15 December 2016

RE: 1 Denison Street, North Sydney - MP 08_0238 MOD 6; MP 08_0238 MOD 7

On the basis of Council's resolution, the following comments are made to the proposed modified conditions of consent. Suggested changes to conditions are in **red** and comments are in *italics* after each condition.

B1

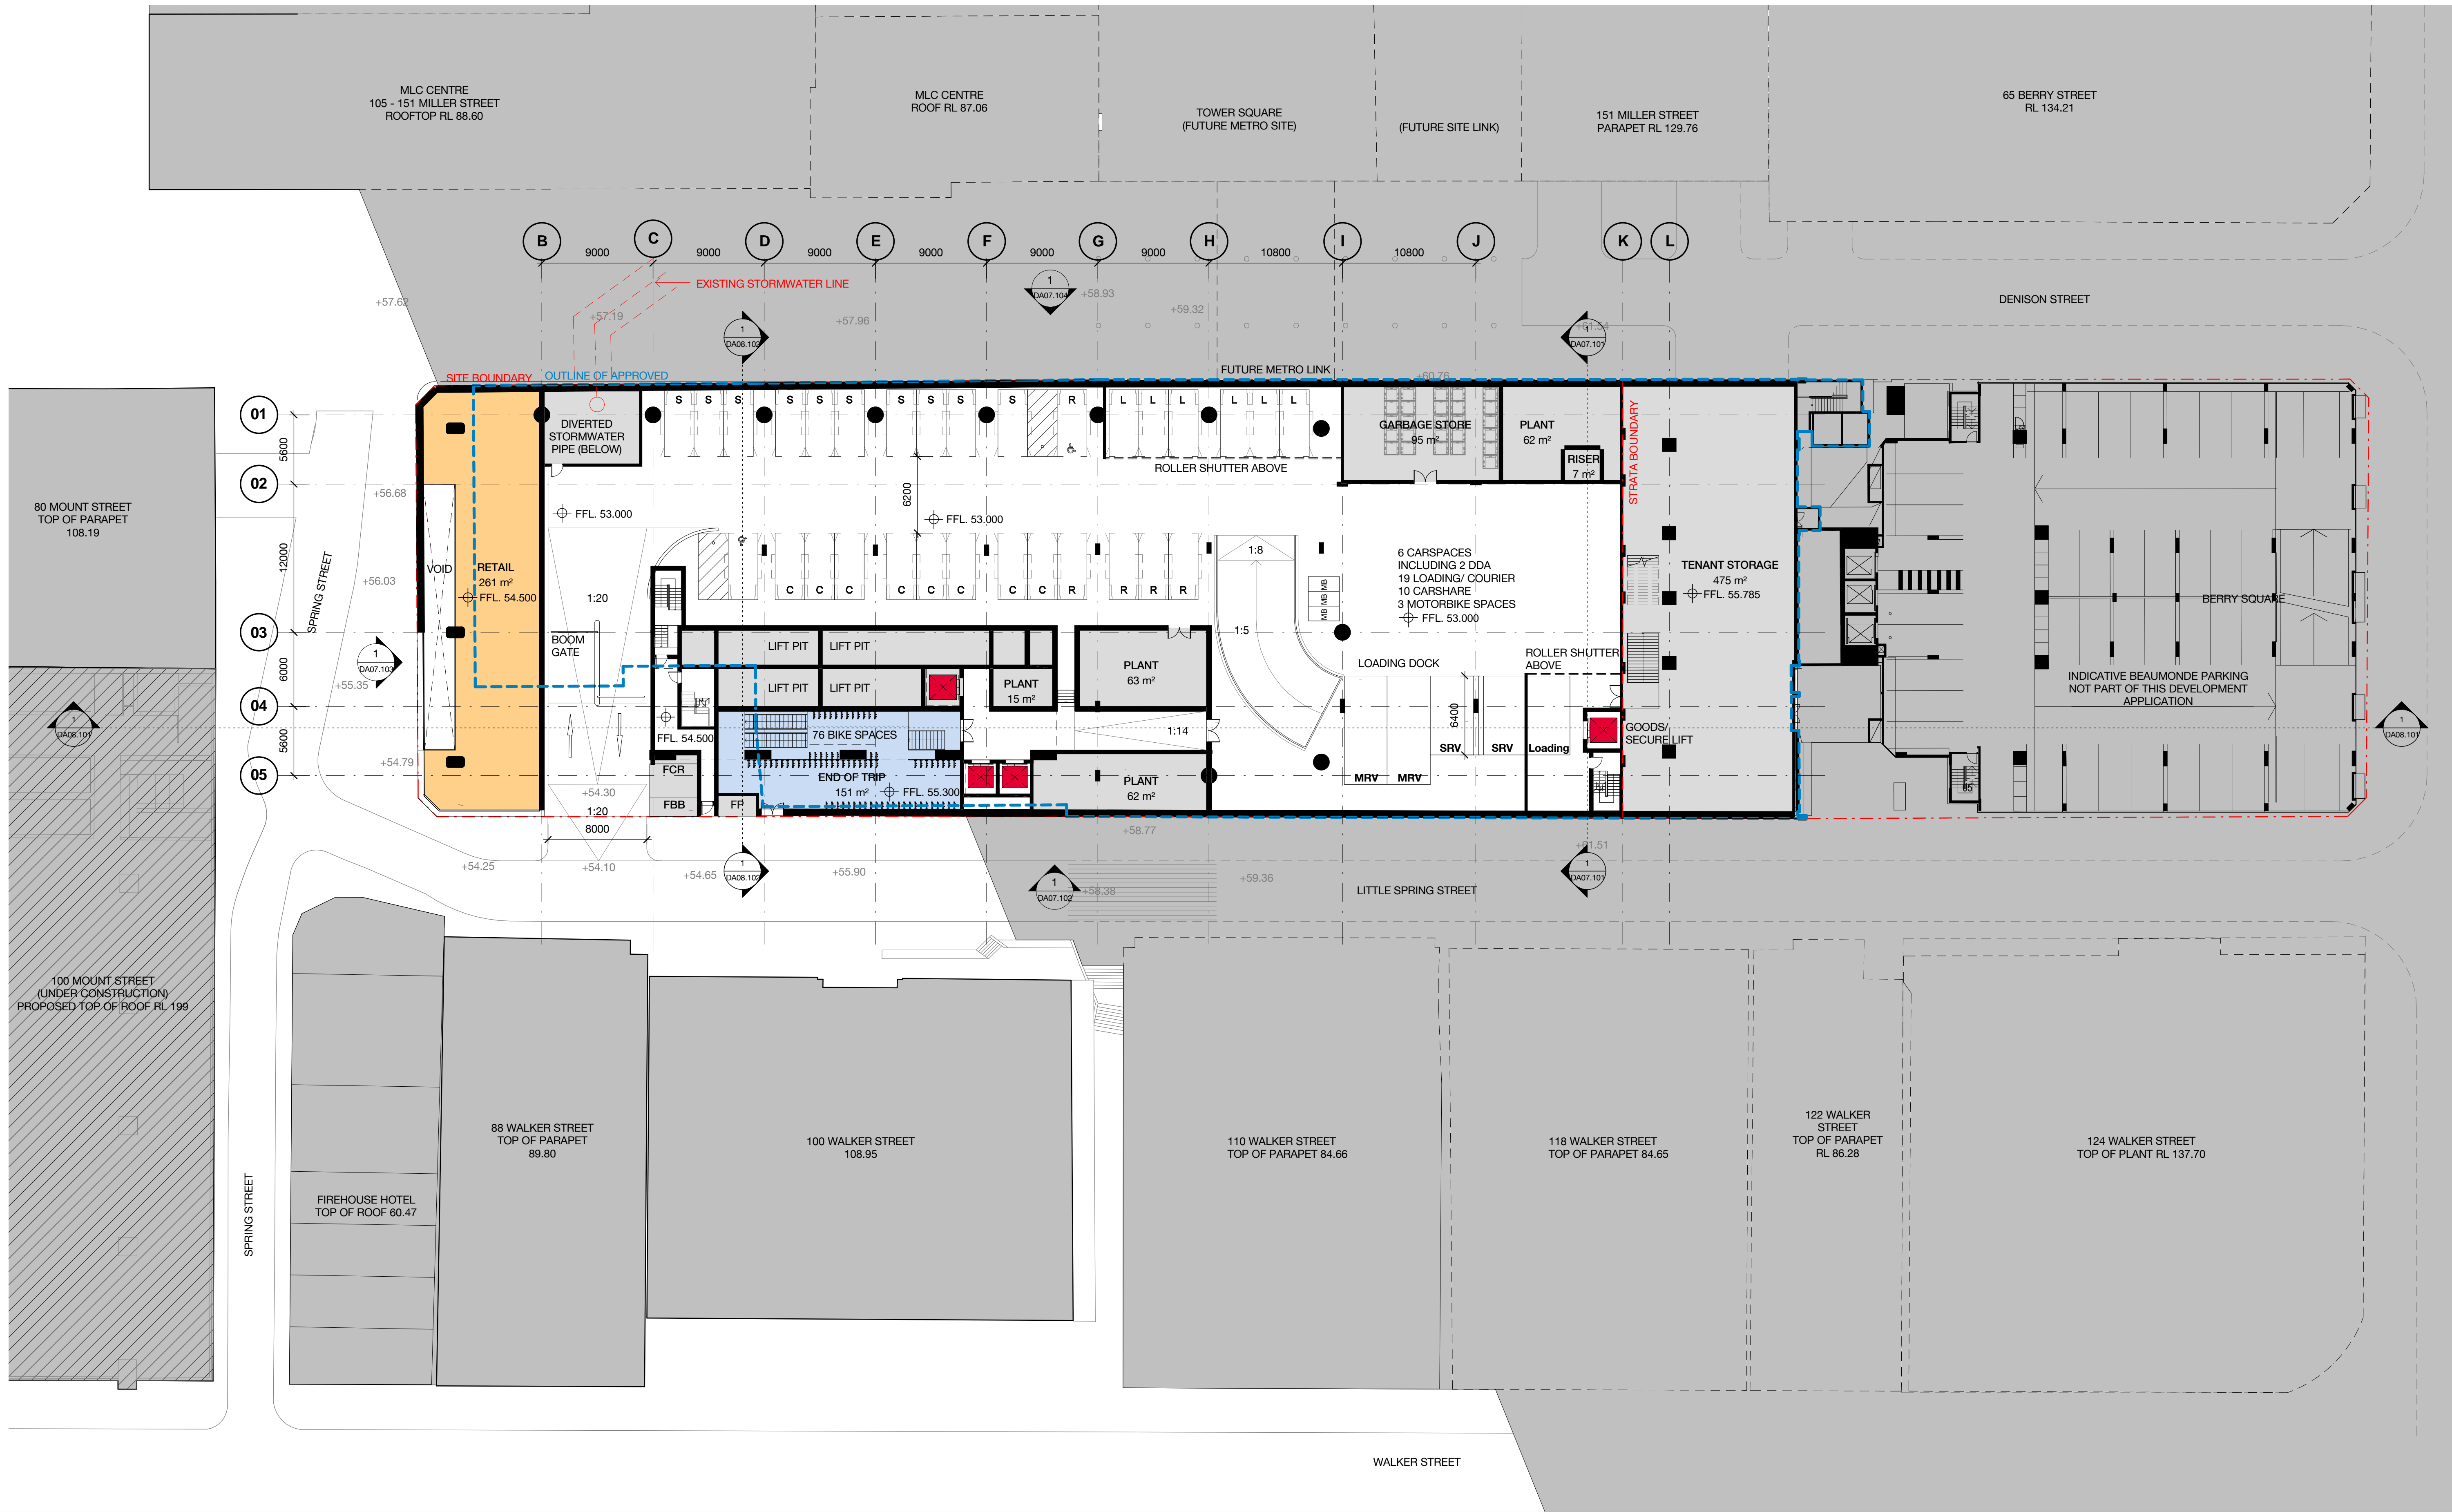
The Proponent shall allocate to Council a minimum of **forty (40)** ~~forty-two (42)~~ car parking spaces **and ?? motorcycle spaces** ~~and twenty-seven (27) motorcycle spaces~~ **commencing** at Basement 1 level of the commercial tower as public parking. Details of the allocation of the required spaces shall be provided to the Department and the Certifying Authority prior to the issue of the relevant Construction Certificate for the Commercial Tower excluding for any initial works.

The new owner now proposes to delete the public parking on site and provide 10 spaces for car share (such as Go Get). The provision of car share spaces does not compensate for the loss of the public metered parking. The public on street parking that will be lost through this development needs to be replaced so that parking is still available for short term visitors and Council does not suffer lost revenue. The proposal to delete the public car park is not supported. The proposed modification with its changes to Denison Street and the public domain will result in the loss of 40 existing on street public parking spaces with 27 of those spaces being metered.

Council does not accept deletion of public parking and seeks minimum of 40 spaces together with motorcycle parking that is to be removed at street level. The public parking would of course be available to visitors to the new commercial building as well as the general public. It may also be possible for the next parking level to be available after hours and on the weekends for additional public parking and part of the area to be managed by Council.
